Application for a Non-Material Amendment Following a Grant of Planning Permission

Davenport Road

Erection of single storey rear extension following the demolition of the existing lean-to.

FP/251/21/HH

Proposed East Elevation

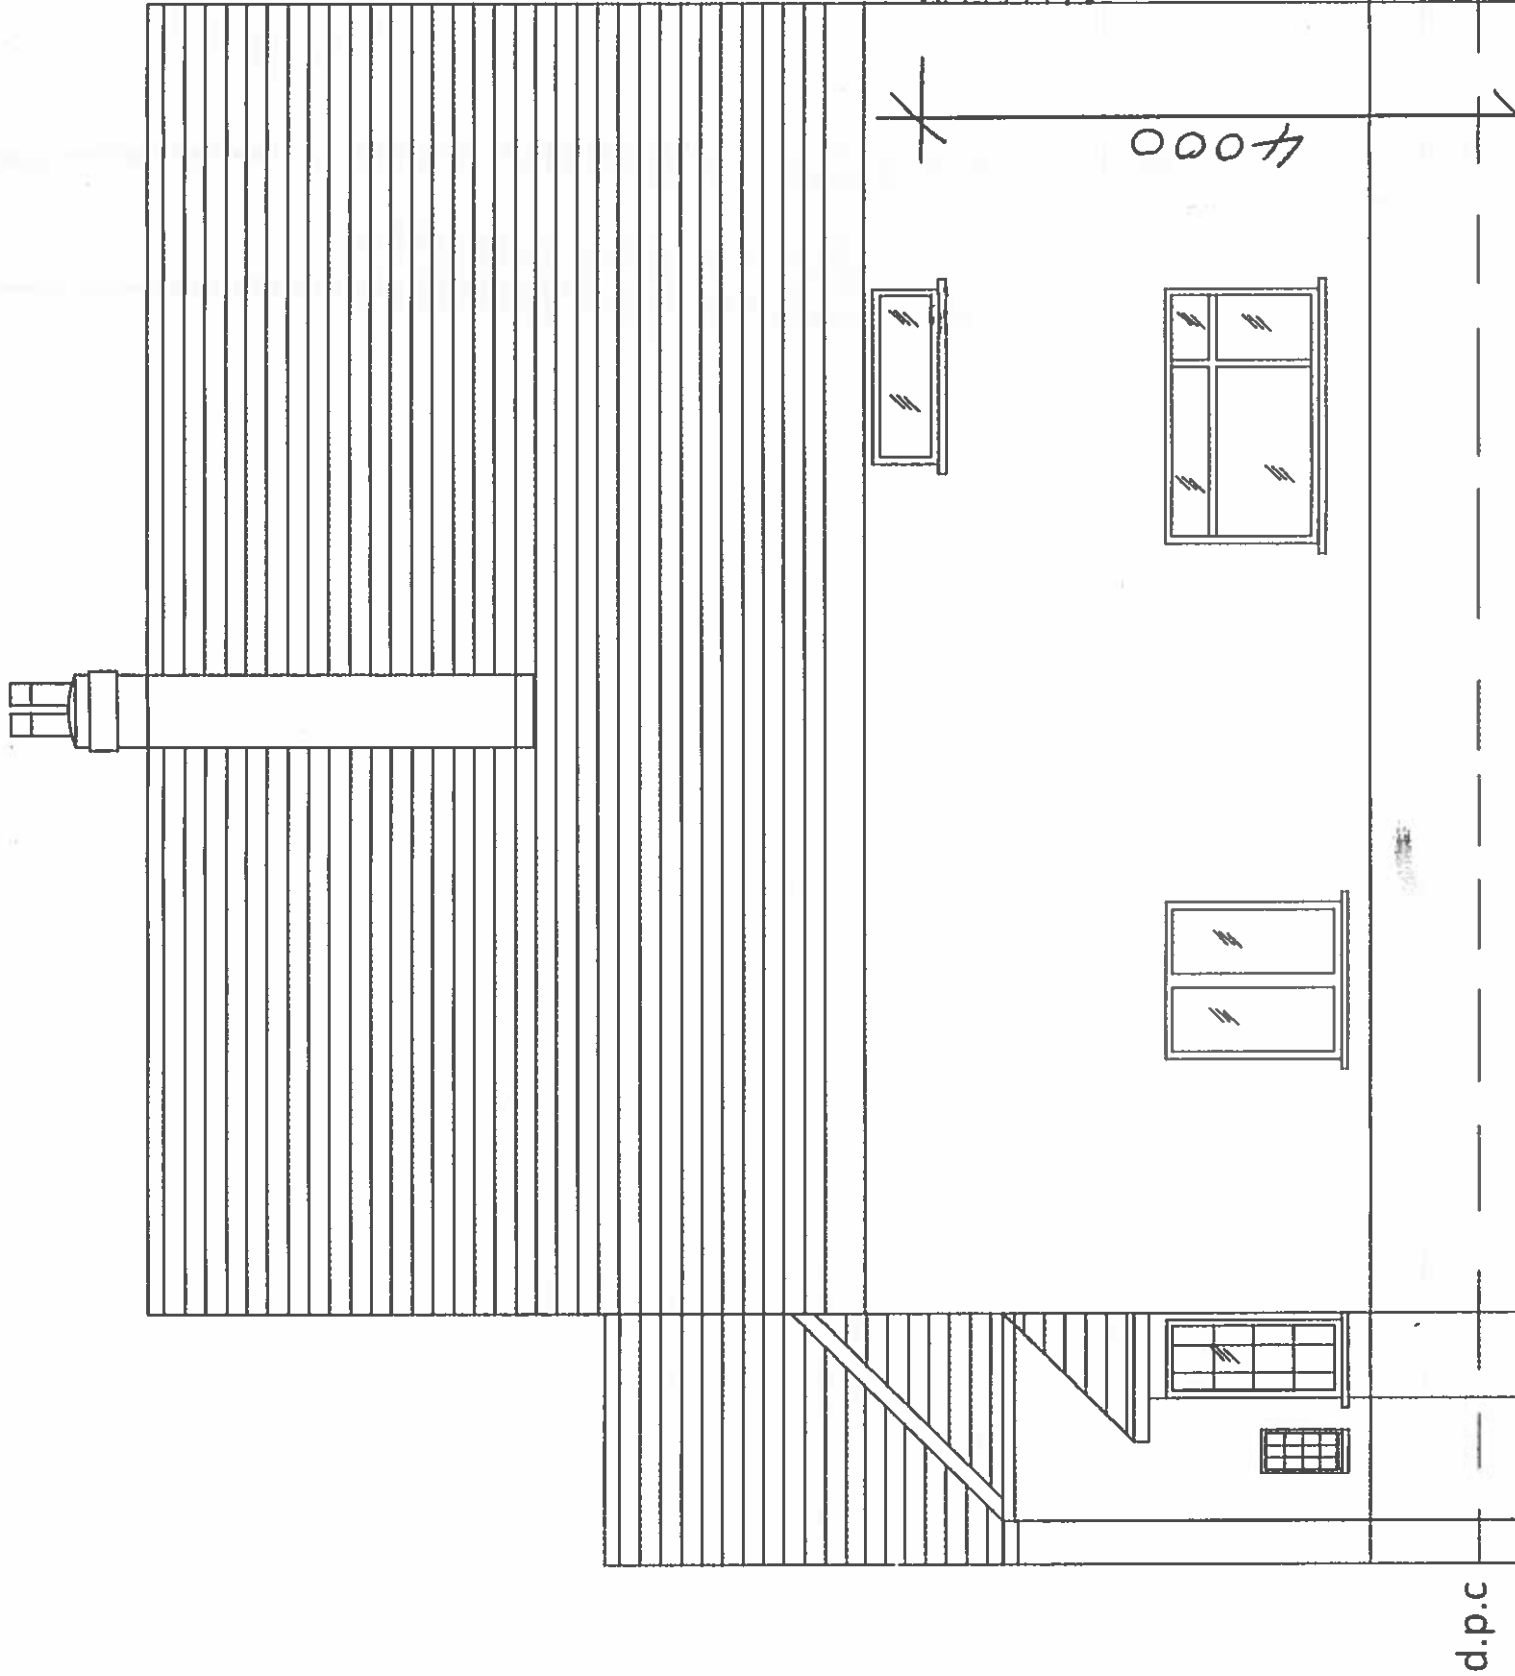
The attached drawings show a mansard type roof -- mirroring the pitch of the existing house roof, with a flat roof behind.
The overall height of the extension will be slightly lower.
The tiles will match the existing house.

As originally drawn the height of the ridge does not quite fit under the bathroom window sill.
Without this amendment it will not be possible to provide an appropriate waterproof flashing

REV Proposed North Elevation 006 Rev A
REV Proposed East Elevation 007 Rev A
Rev Roof detail
